From:
To: [DCAdmin](#)
Subject: Comments for - Planning - 2021/62/93965/W – 26, Greenhill Bank Road, New Mill, HD91ER,
Date: 15 December 2021 09:33:22

Further to application number **2021/62/93965/W** – 26, Greenhill Bank Road, New Mill, HD91ER. I would like to put forward the following comments.

SITE PLAN - 1/500

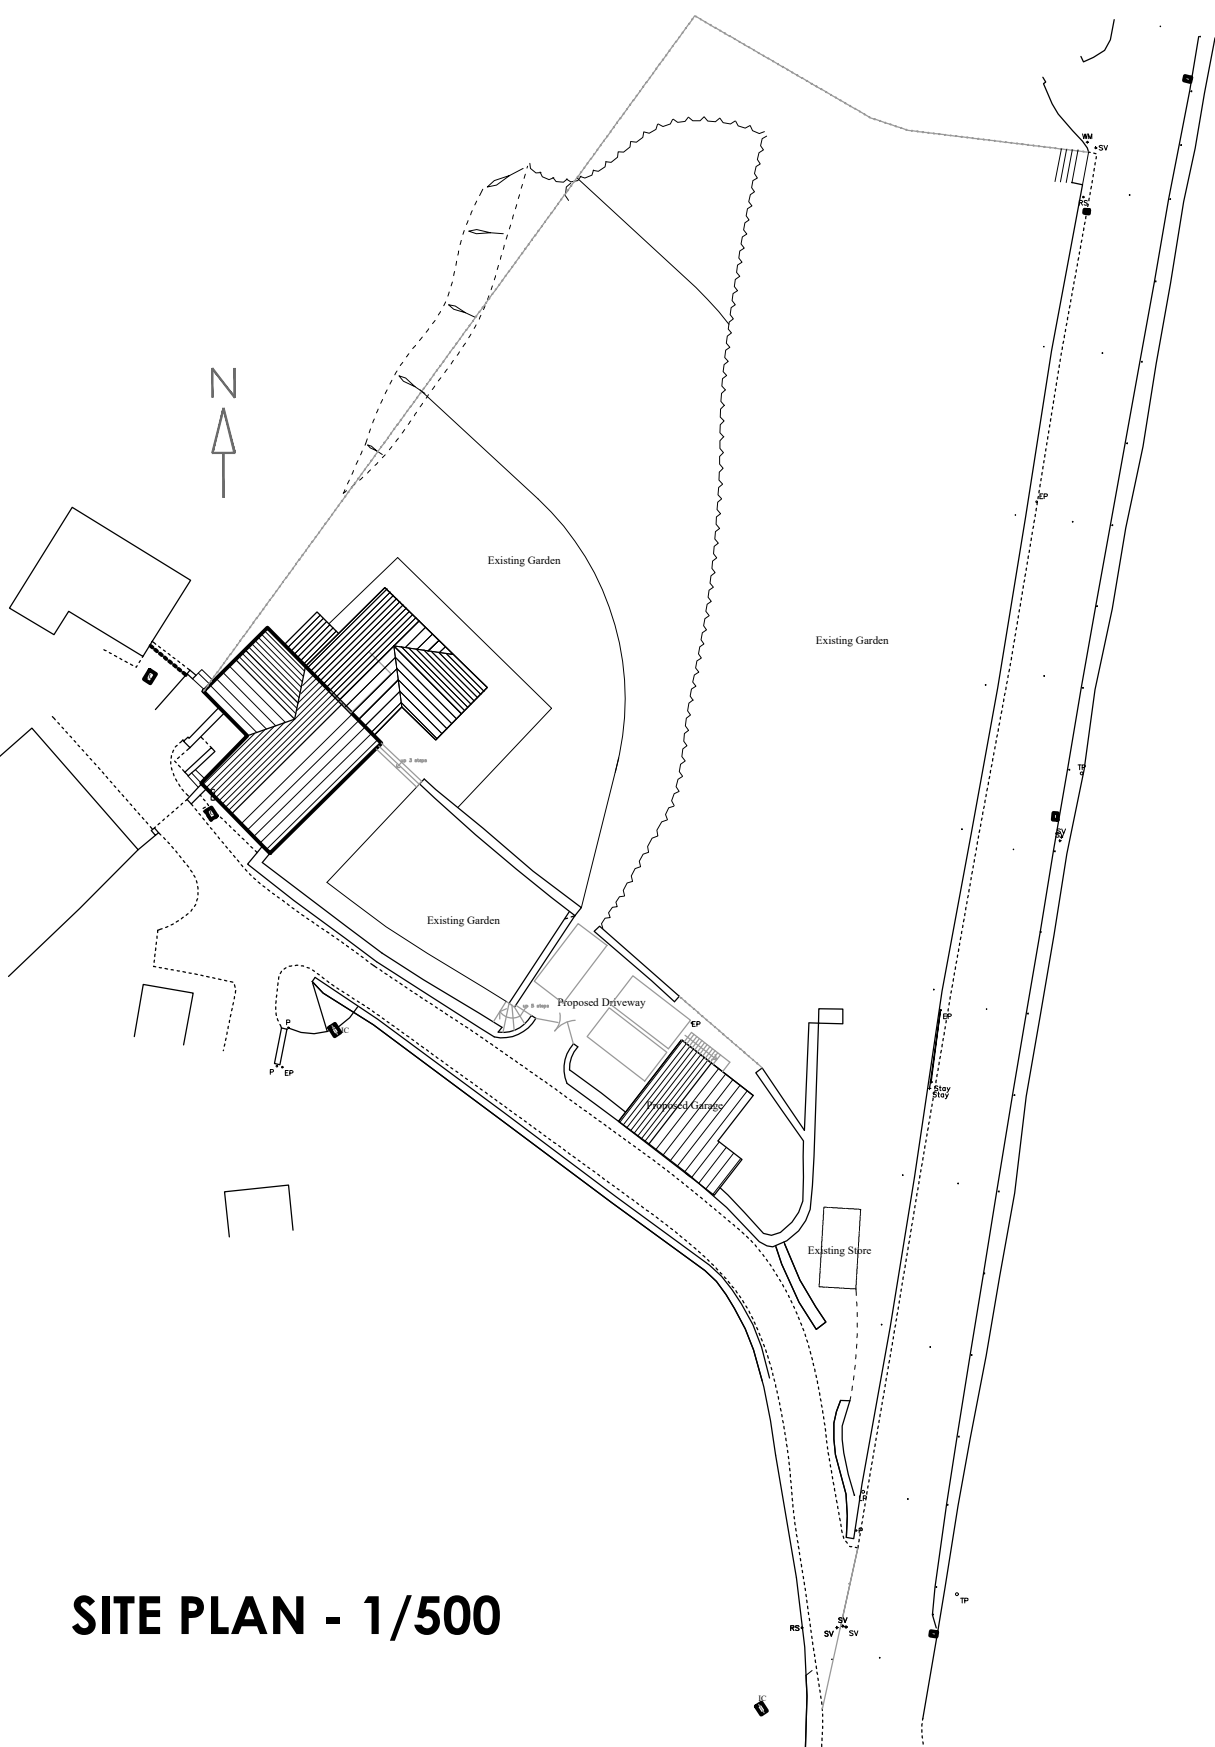
<!--[if !supportLists]-->• <!--[endif]-->Looking at the plans the proposed 'passing place' does not look sufficient for the purpose, as the existing lane is very narrow and the proposed 'passing place' is little more than a turning entrance to the proposed garage forecourt.

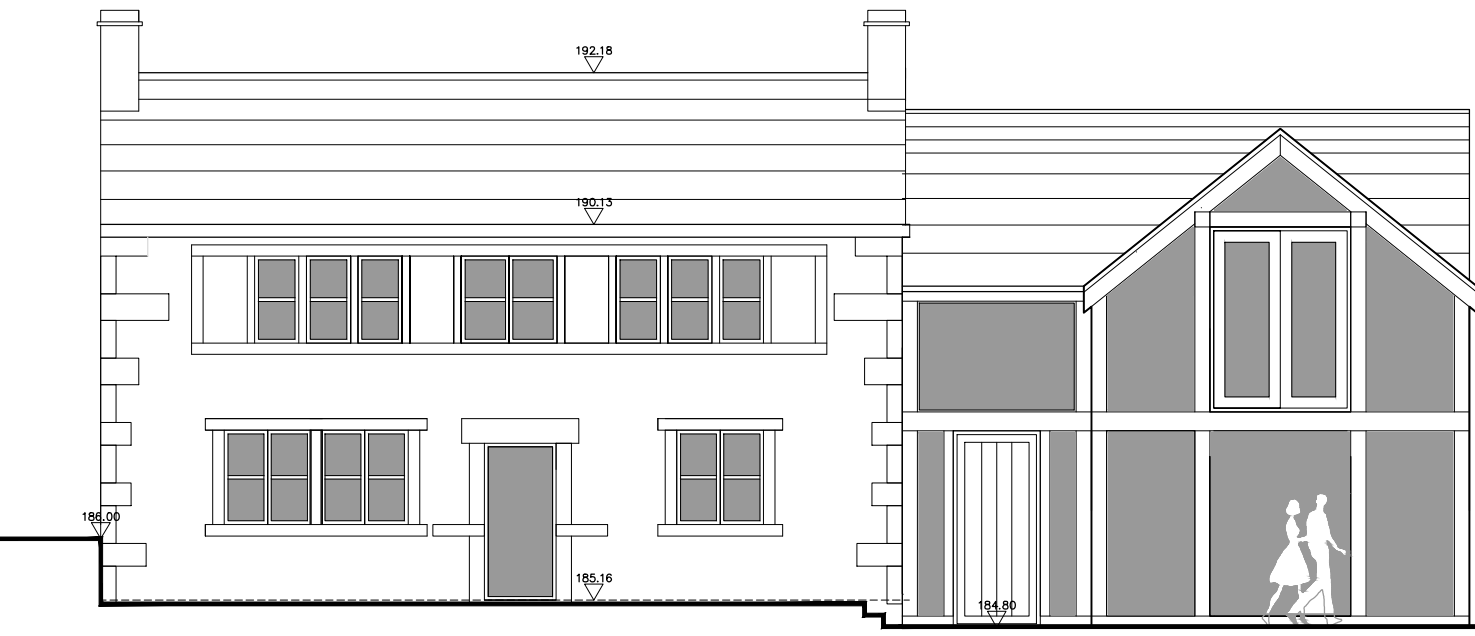
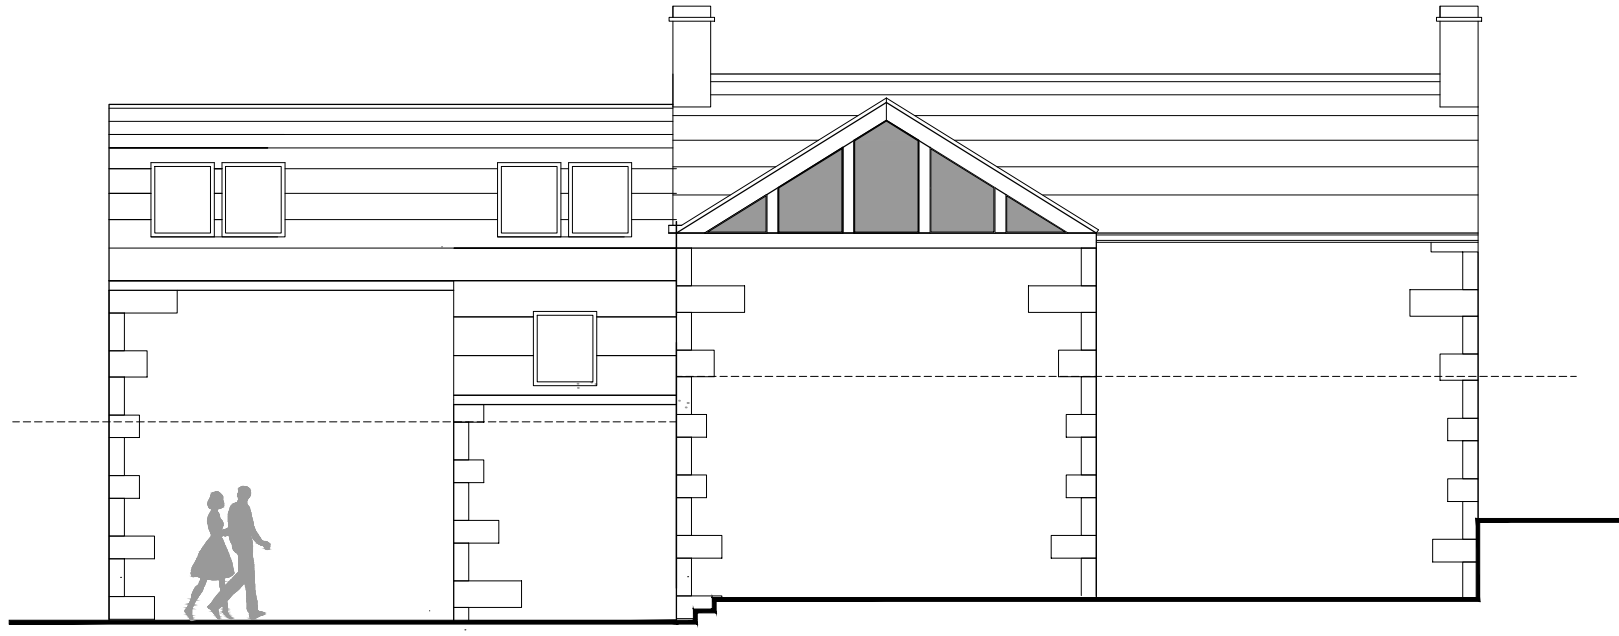
<!--[if !supportLists]-->• <!--[endif]-->I feel it is a wholly inappropriate development to build a new build double height double storey garage in the designated Green Belt – there is very little detail as to why the new garage building has to be double storey in height.

<!--[if !supportLists]-->• <!--[endif]-->I might add that my property will be looking directly into the second storey of the proposed double height garage and so not only will my privacy be affected looking back up the steep hill, but any privacy within the office accommodation will be wholly overlooked by my entire property – top and bottom windows, as my property faces fully onto the existing garden and proposed new build in Green Belt.
